Householder Delegated Report

Application No.	24/01879/F
Site Address	North Arms Inn, Mills Lane, Wroxton, Oxfordshire, OX15 6PY
Proposal	Single storey kitchen extension; new and restored stone boundary walls
Amended Plans	Amended Plans received that reduce the height of the wall to Church Street and a boundary wall between the site and the neighbouring property, The Old Laundry.

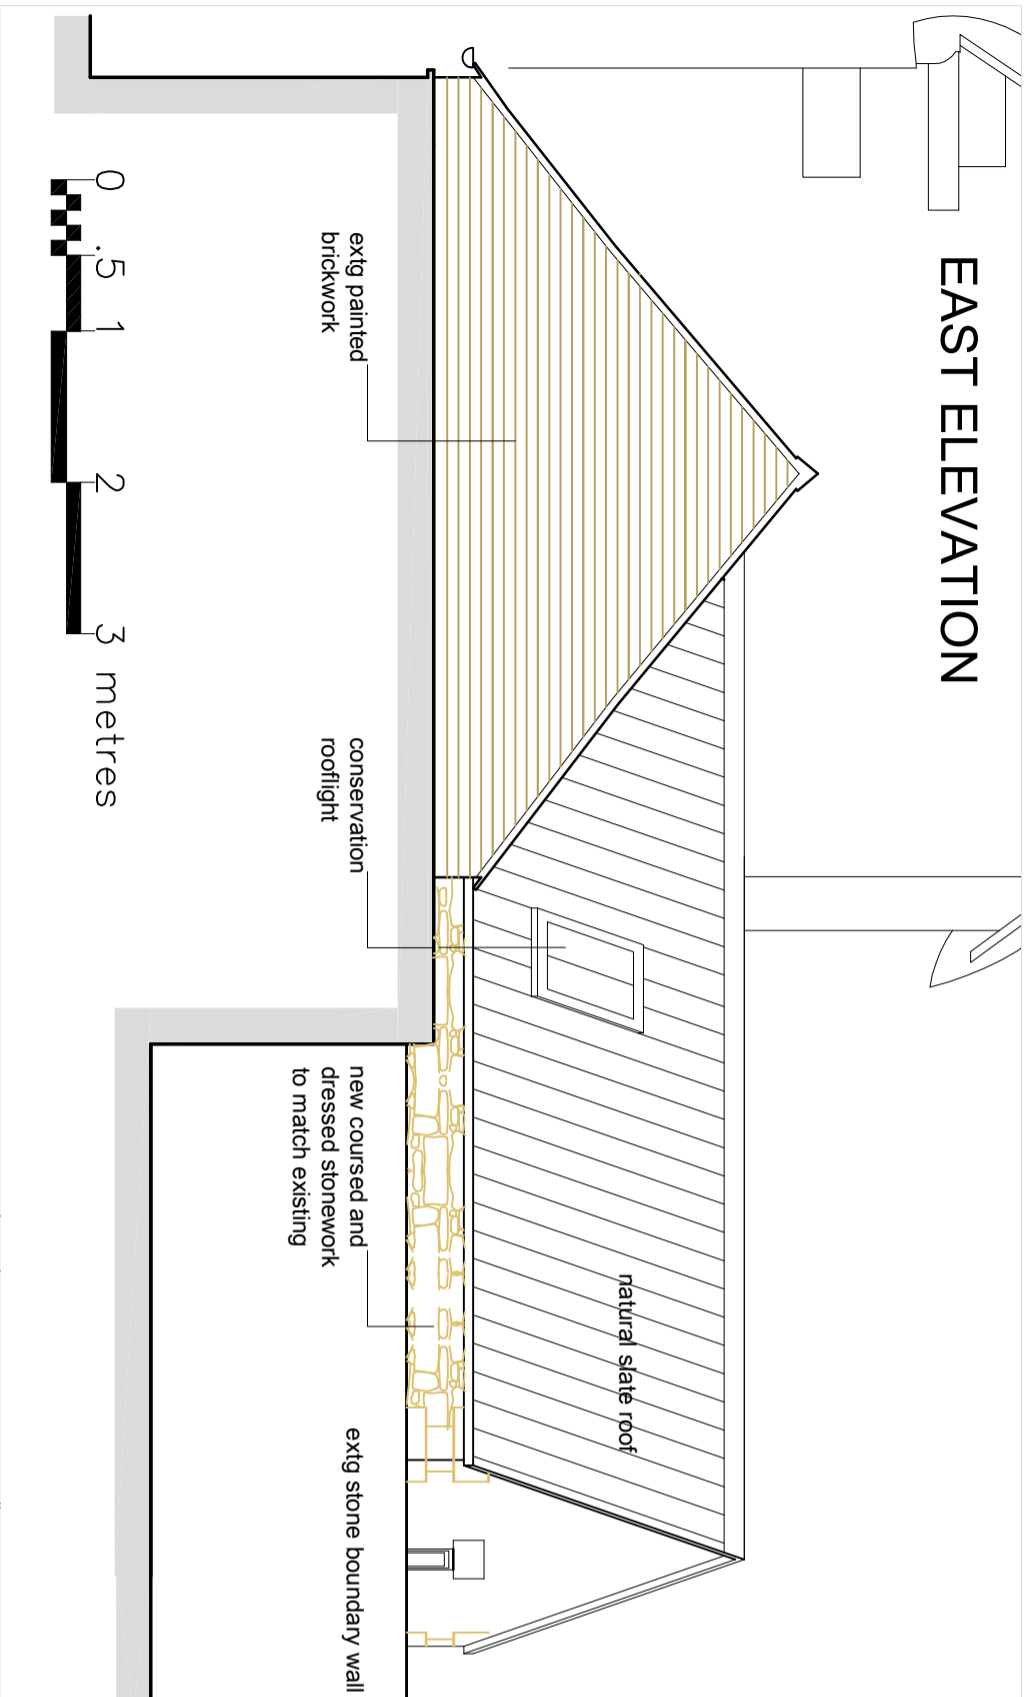
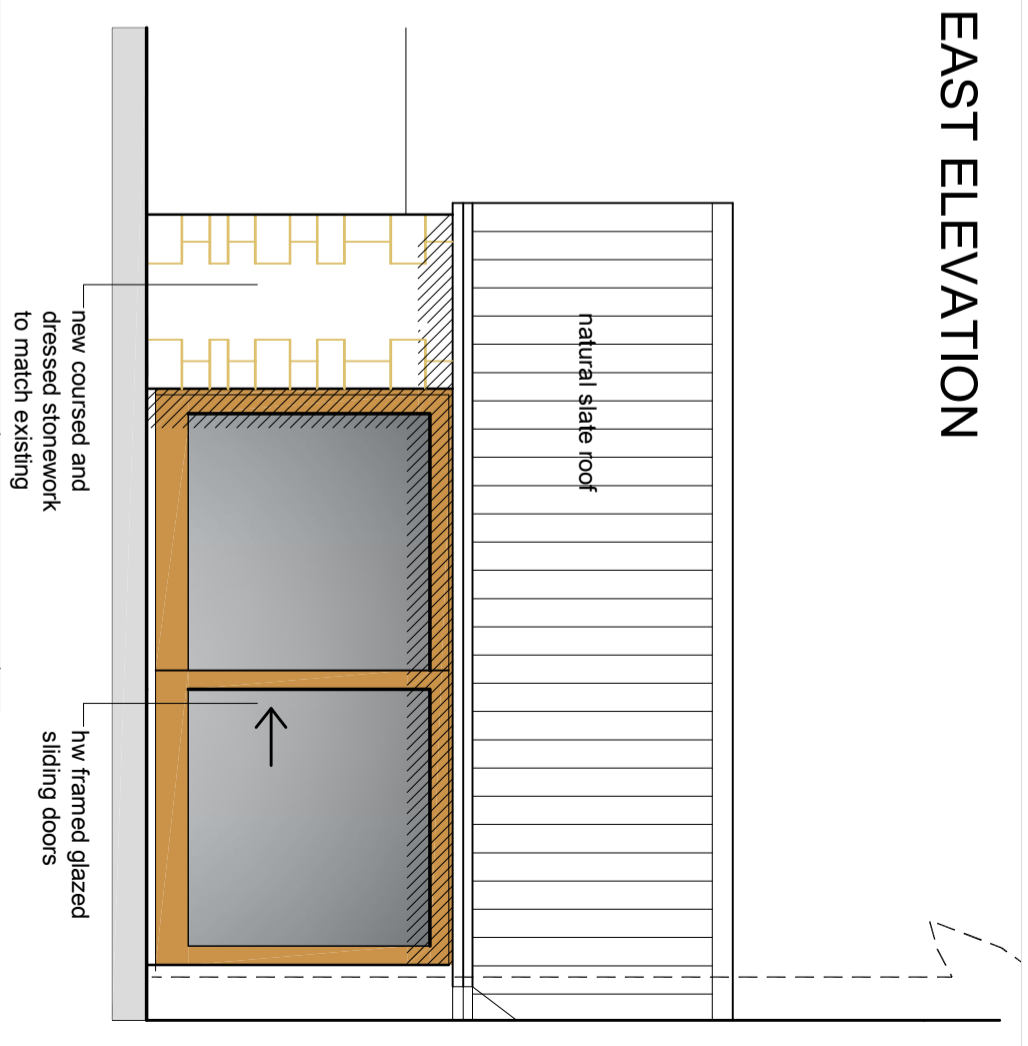
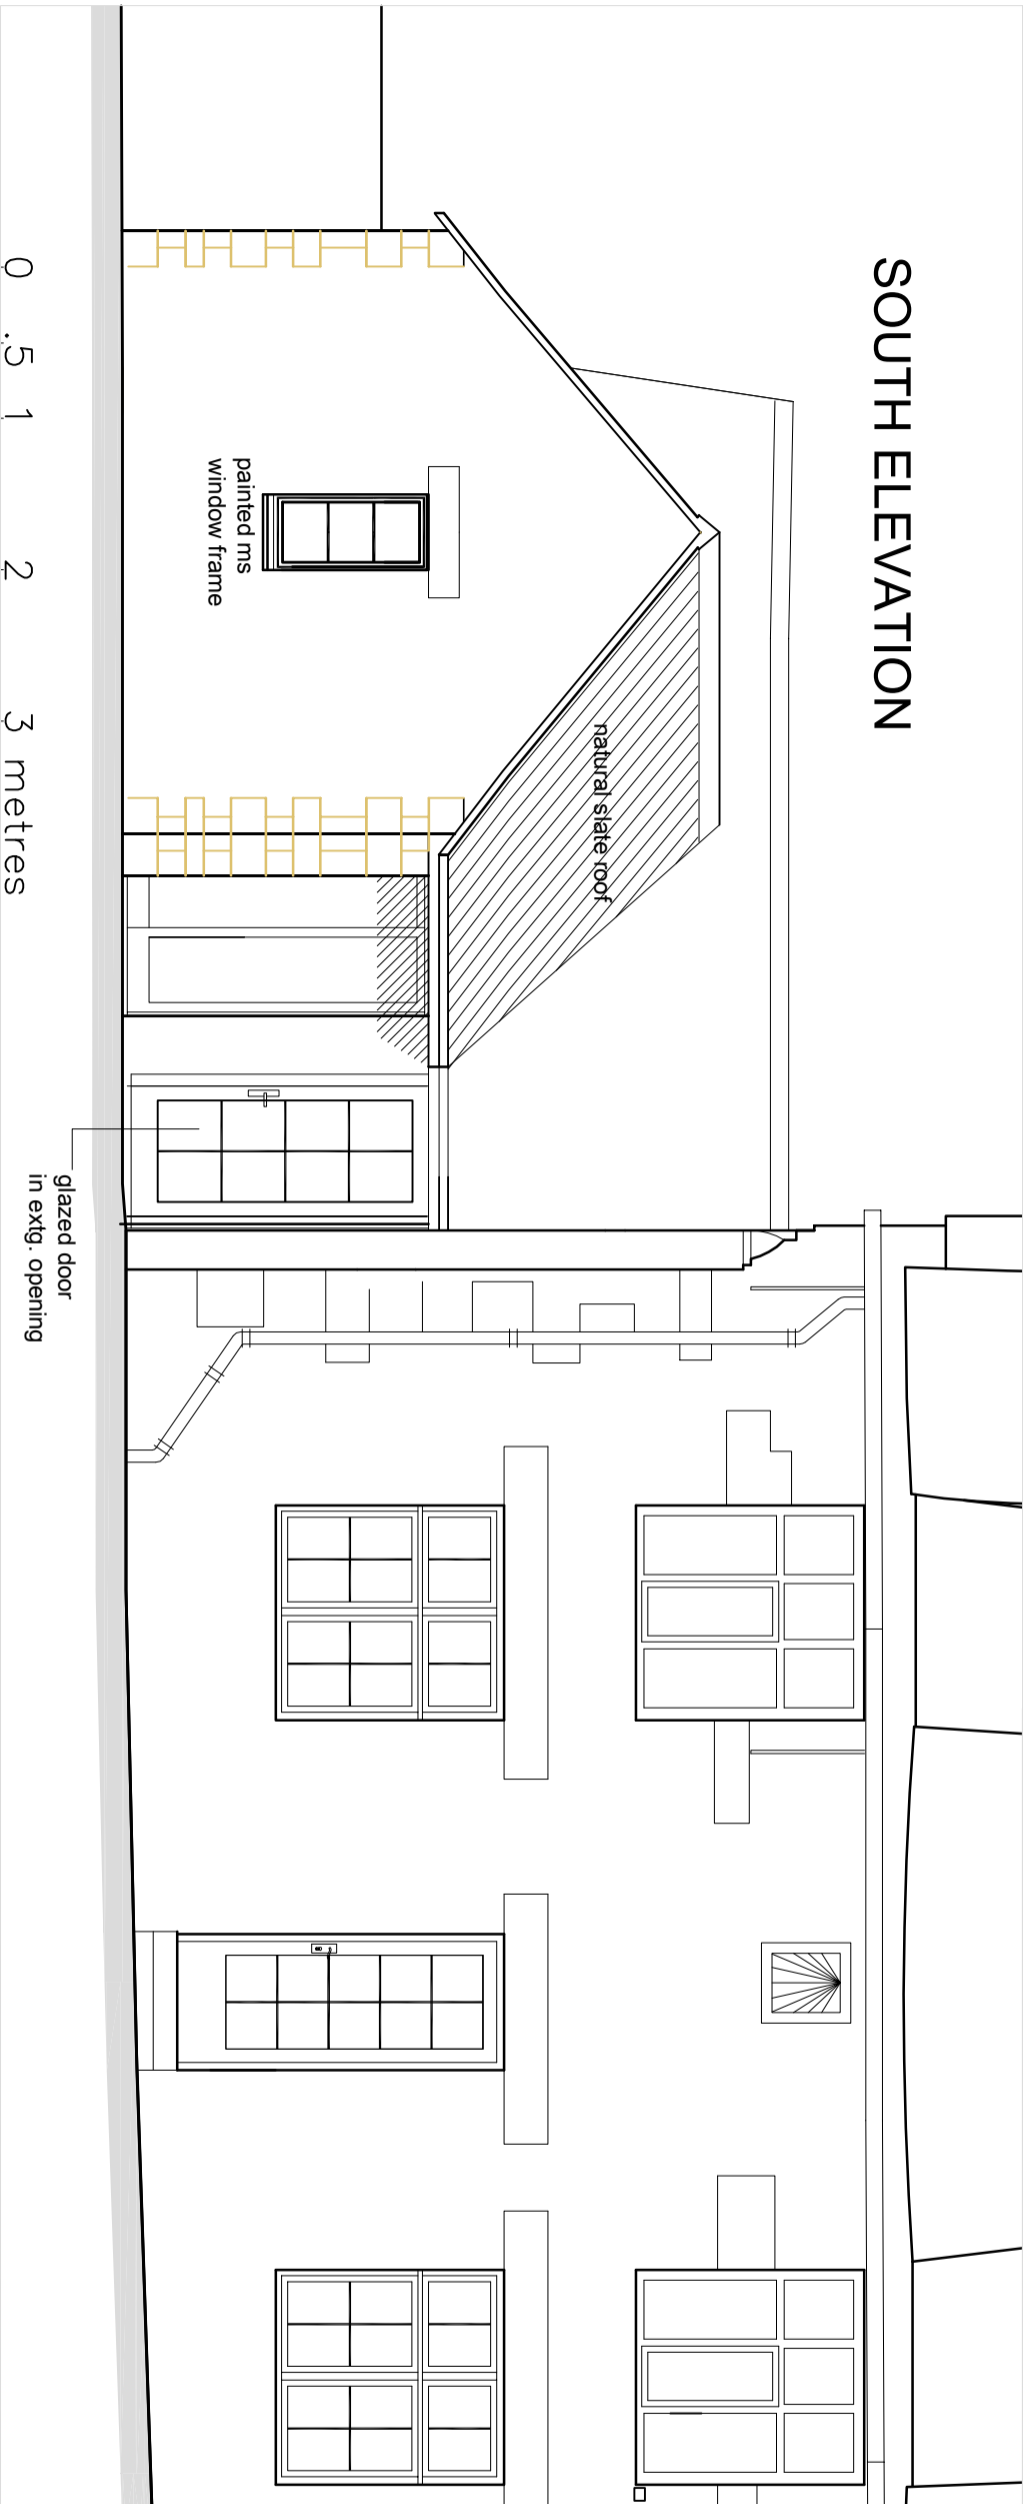
The proposed extension is considered to be of a scale and design appropriate to the listed building and will preserve the character and appearance of the Conservation Area.

8. Prior to the commencement of the extension above slab level details of how rainwater will be disposed of to the western elevation of the extension shall be submitted to and approved in writing by the Local Planning Authority.

22070/P23

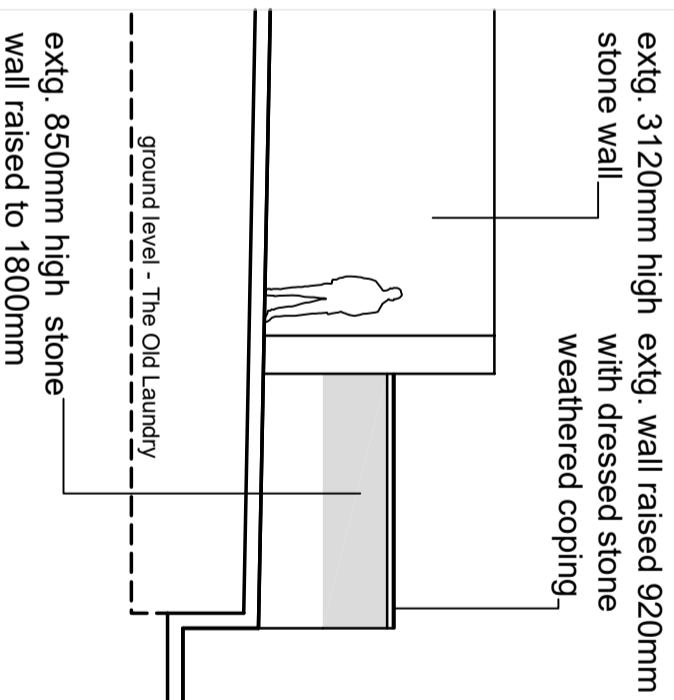
Consultees	<ol style="list-style-type: none"> 1. Clerk to Wroxton and Balscote PC – No response received regarding 24/01879/F but no objections to application 24/01880/LB 2. Conservation (CDC) – Original comments – Extension: The outline support at preapp was based on the extension being big enough for a table. The current proposal is longer than the preapp version by approximately 600mm. The proposed storage units look awkward running down the long side as it meets the kitchen units, the units to the gable would be neater on their own. <p>Condition: Sample walling Sample slate to match Welsh on side extension, blue clay ridge to match Rooflight detail – top hung fitted between the rafter Eaves detail including junction with existing extension/junction with boundary – avoiding a 'dead cat' space. Verge detail Joinery details for windows, include depth of recess, lintol detail and threshold RWGs to be black metal (detail to be shown on eaves details) – we also need details of how rainwater will be disposed to the west side of the extension. Detail of structural opening to be formed in existing extension</p> <p>Walls: They have added in increasing the height of the wall on the boundaries, can we have more information on the impact for the neighbouring properties, when I visited site there was site hoarding and the gate was blocked off. The 850mm wall to the east is to be increased to 2.4m – I can't see existing and proposed elevations?</p> <p>The wall to the south is to be increased to 1800 – how would this compare with the opposite wall – in terms of hierarchy, Wroxton Abbey should take precedence? 1800 would make the proposed door very short, a similar door has a frame and people would need to duck under this. I have no objection to it being raised to the same height as the adjacent wall – the gate should be no higher than the coping, this likely means there will be no frame to the top. At Tadmarton a wall was increased in height locally, to allow a useable door in the wall, I can't find a similar Wroxton precedent.</p>

<p>We need more information and if acceptable will need joinery details for the gate, including ironmongery/sample for the walling, quoins to opening, and coping.</p> <p>3. Conservation (CDC) – Final comments - Supports the amendments. Please refer back to suggested conditions</p>
Neighbours	<p>There have been 0 letters of objection</p> <p>There have been 0 letters of support</p>

The proposals for raising the height of boundary walls have been amended. The wall to Church Street has been reduced in height from the originally proposed height due to the conflict with the hierarchy of the boundary walls in the area. It is considered that the boundary wall to Wroxton College (Grade 1 listed building) should take precedence. The height of part of the boundary wall between the site and The Old Laundry has also been reduced from the original submission. Officers were concerned about the overbearing impact of this on the living amenities of the neighbouring property.
